Assessment of Development Application: 1–5 Nelson Road, Lindfield

This assessment reviews the nine-storey residential tower proposed at 1–5 Nelson Road against statutory instruments, design principles, infrastructure capacity, and environmental considerations. It concludes that the proposal does not align with the locality’s low-density character, undermines heritage values, and exceeds the capacity of existing infrastructure. Refusal is recommended.

3. Height, Bulk, and Clause 4.6 Variation

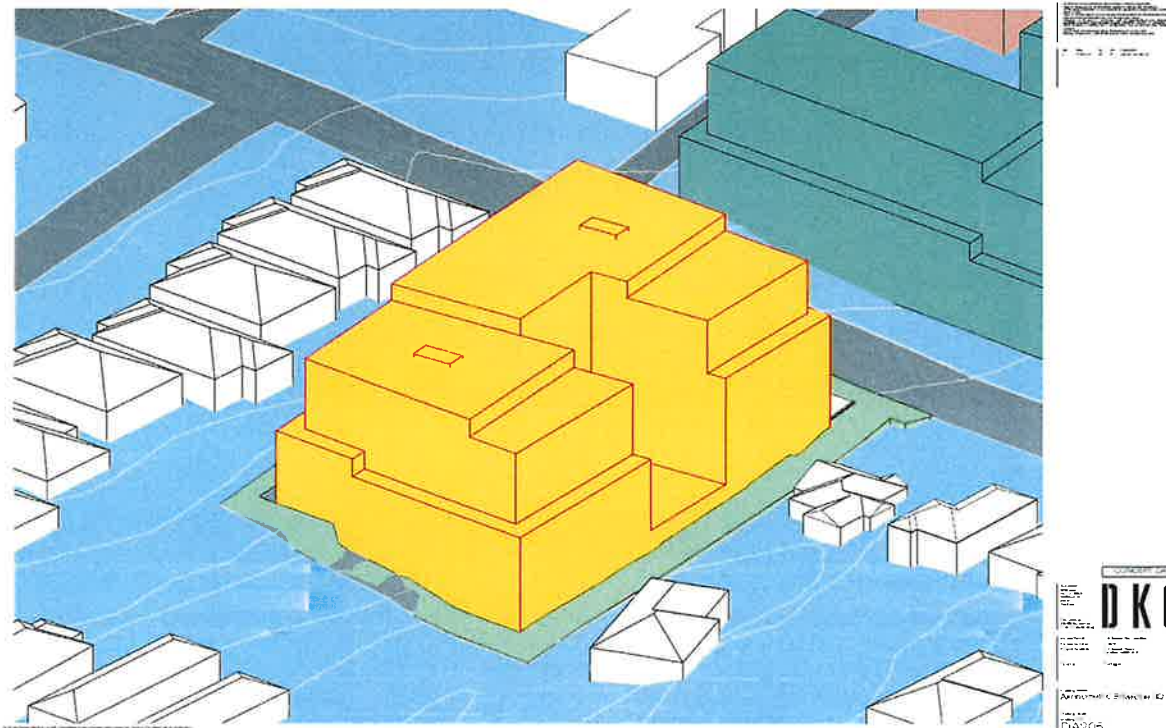
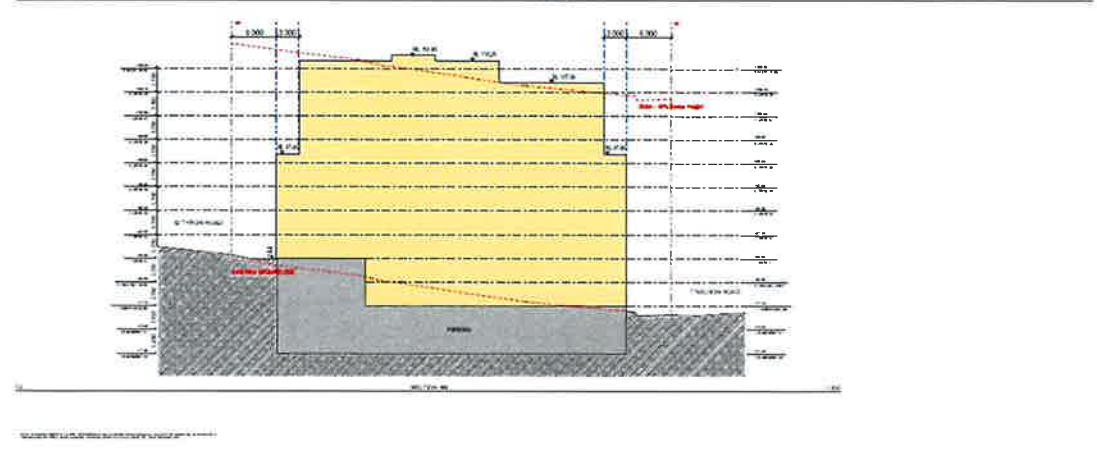
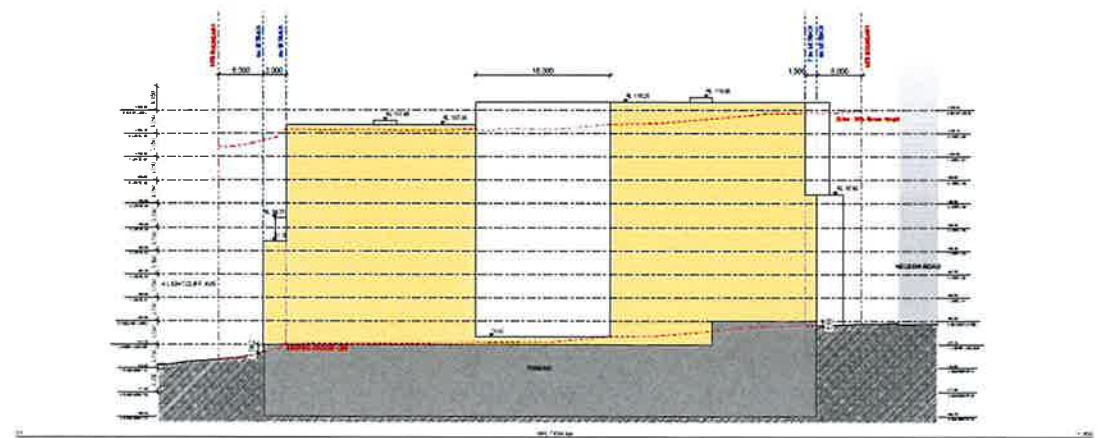
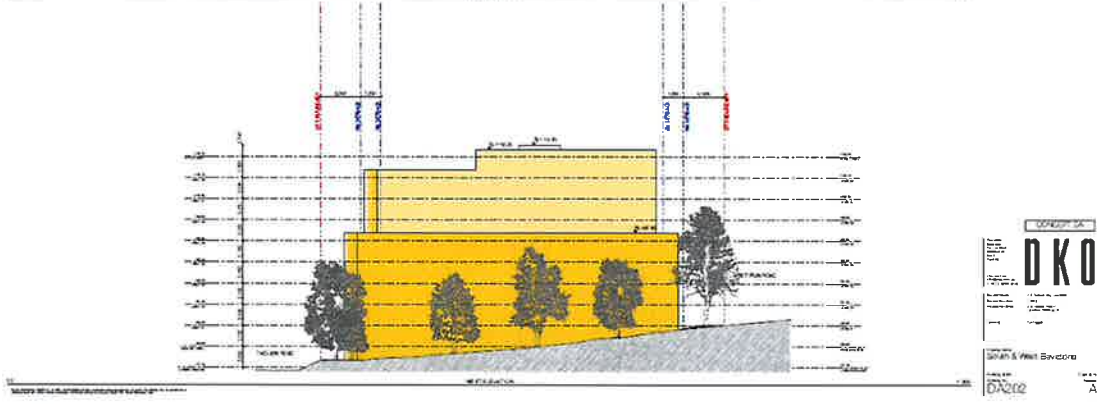
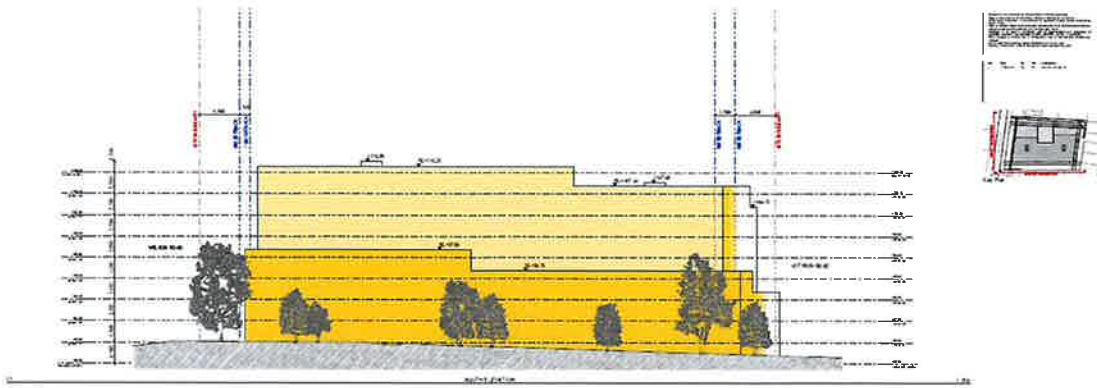
The road’s single-storey buildings embody late 19th- and early 20th-century residential design, many of which contribute to the Lindfield heritage conservation precinct. The proposed 35-metre height far exceeds the surrounding scale, creating an “up-house” effect that disrupts sightlines and diminishes heritage significance.

- Zoning: R2 Low-Density Residential – permits detached housing, dual occupancies; flats are a prohibited use when they exceed two storeys
- Height Standard: 9 metres maximum; the proposal is 35 metres high
- Heritage Conservation: Site falls within a heritage conservation precinct requiring development to conserve cultural significance

Figure 2: Proposed site plan showing the extent of the footprint and existing trees.

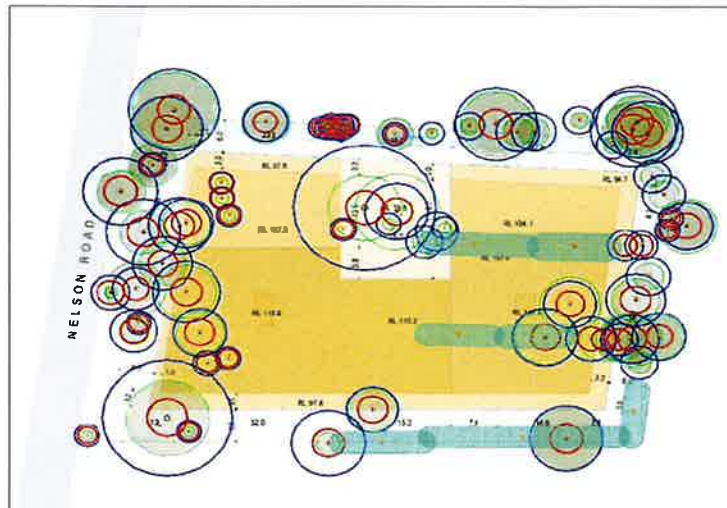
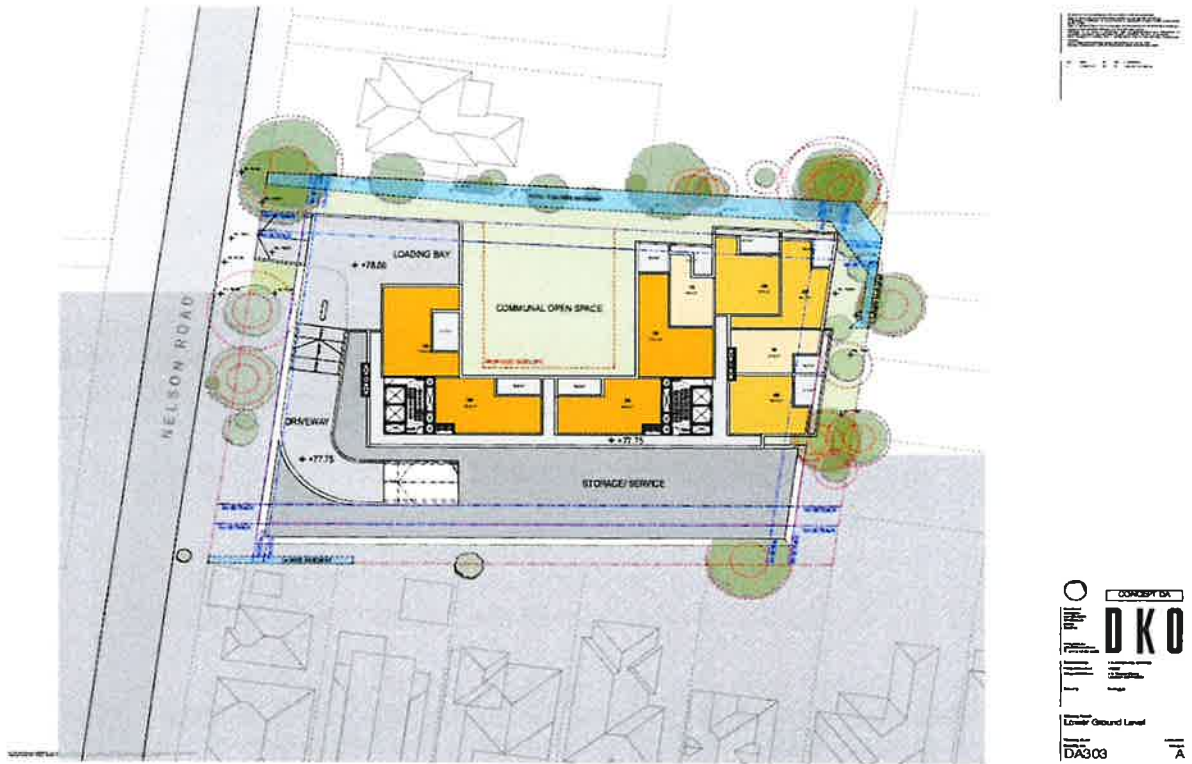
The development footprint necessitates the removal of all on-site mature trees and native understorey, undermining local biodiversity values. The proposal also:

- Contravenes the Ku-ring-gai Urban Canopy Replacement Policy by failing to provide one-for-one tree replacement
 - Increases hard surfaces, exacerbating urban heat island effects
 - Disrupts contiguous wildlife corridors that traverse neighbouring green corridors
-

DEEP SOIL DIAGRAM

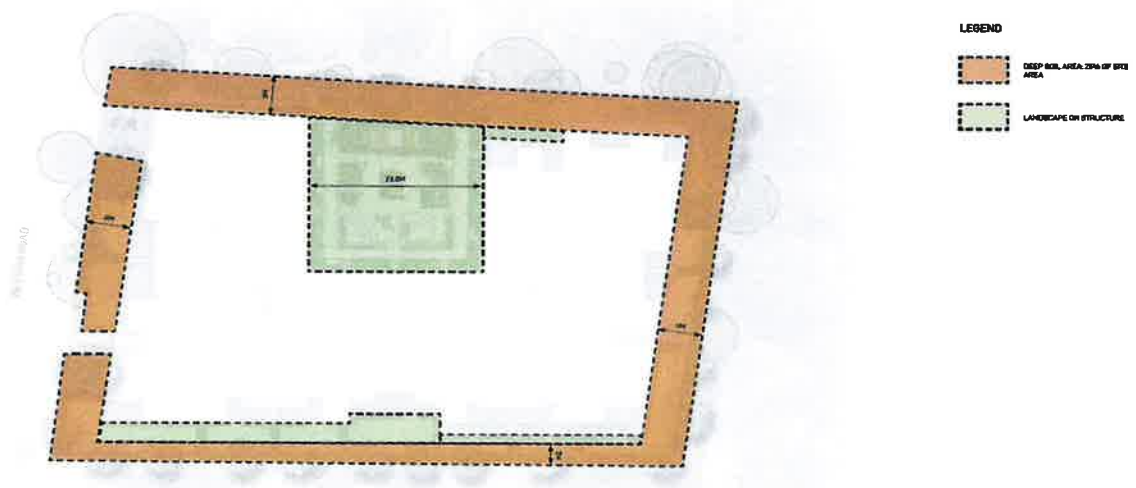
- Height and Bulk: Nine storeys versus the predominant one-storey context
- Setbacks and Landscaping: Minimal street and side setbacks, sparse deep soil planting
- Massing Composition: Monolithic gable with limited façade articulation

1% AEP Provisional Flood Hazard Categories on the subject lot: 5 Nelson Road LINDFIELD NSW 2070

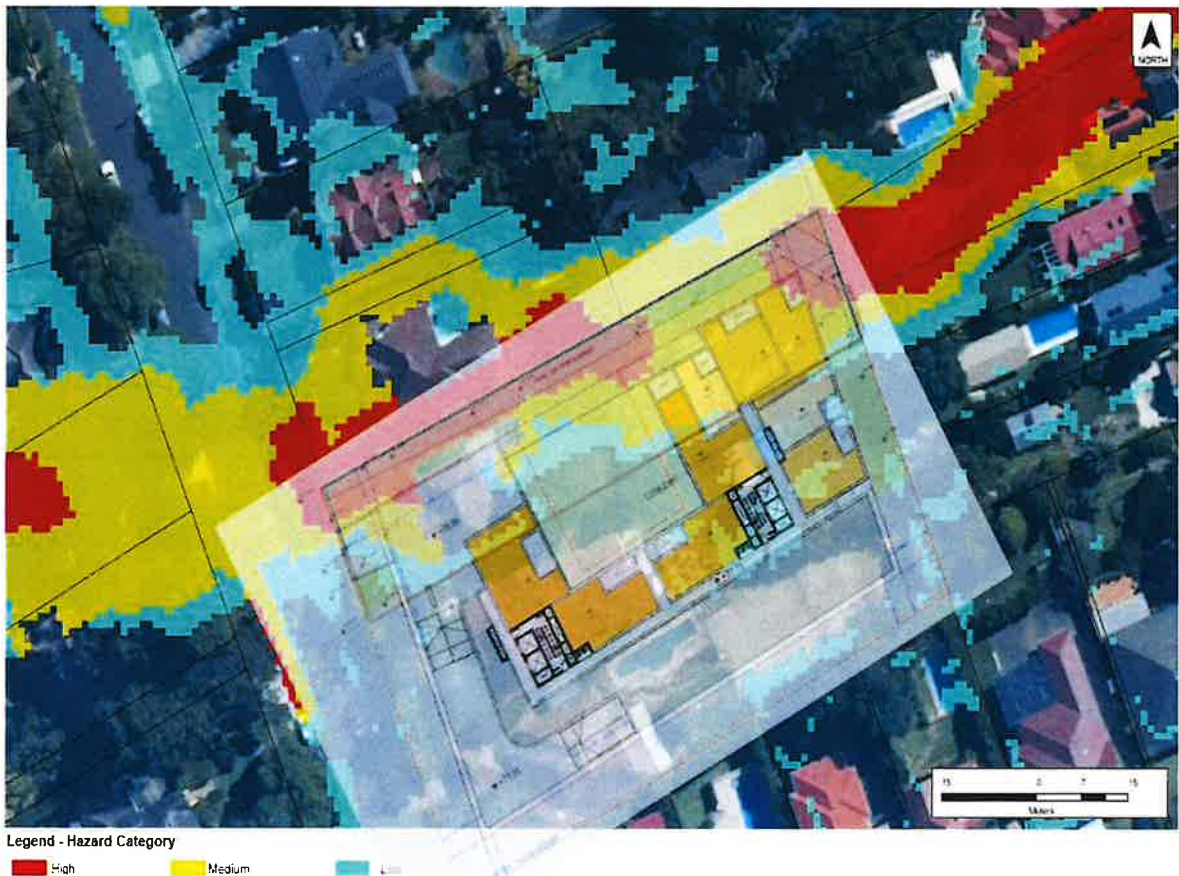
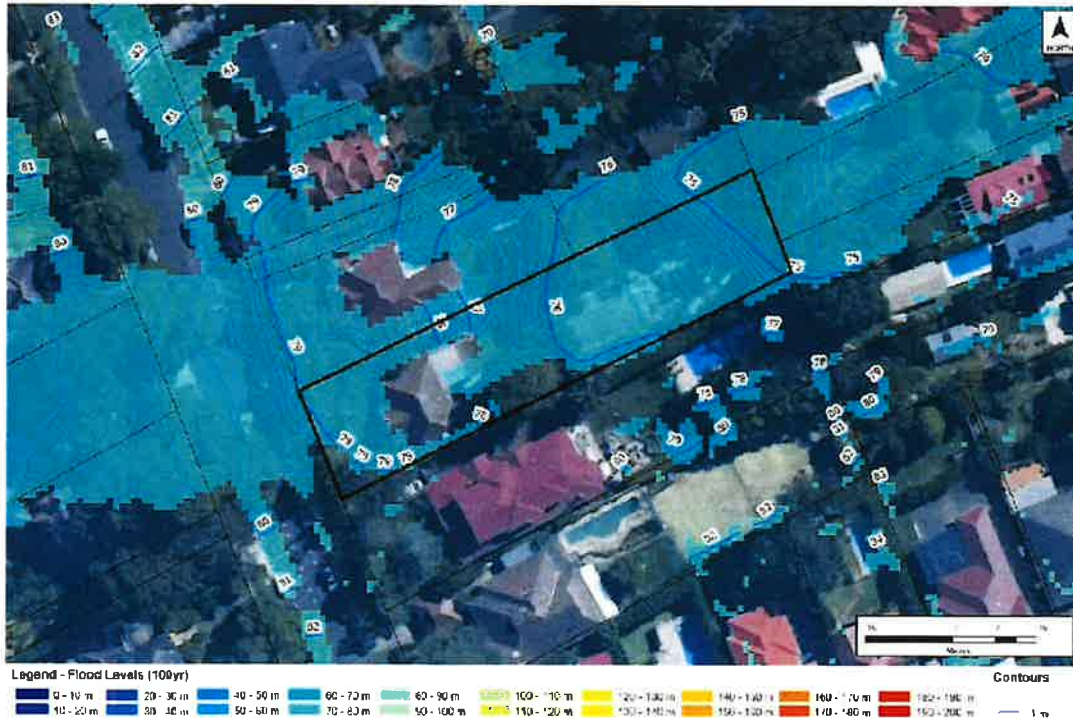
- Heighten flood risk to lower-lying properties
- Require major upgrades to stormwater pits and pipes, for which no supporting evidence is provided
- Potentially discharge to heritage-listed trees' root zones, undermining vegetation health
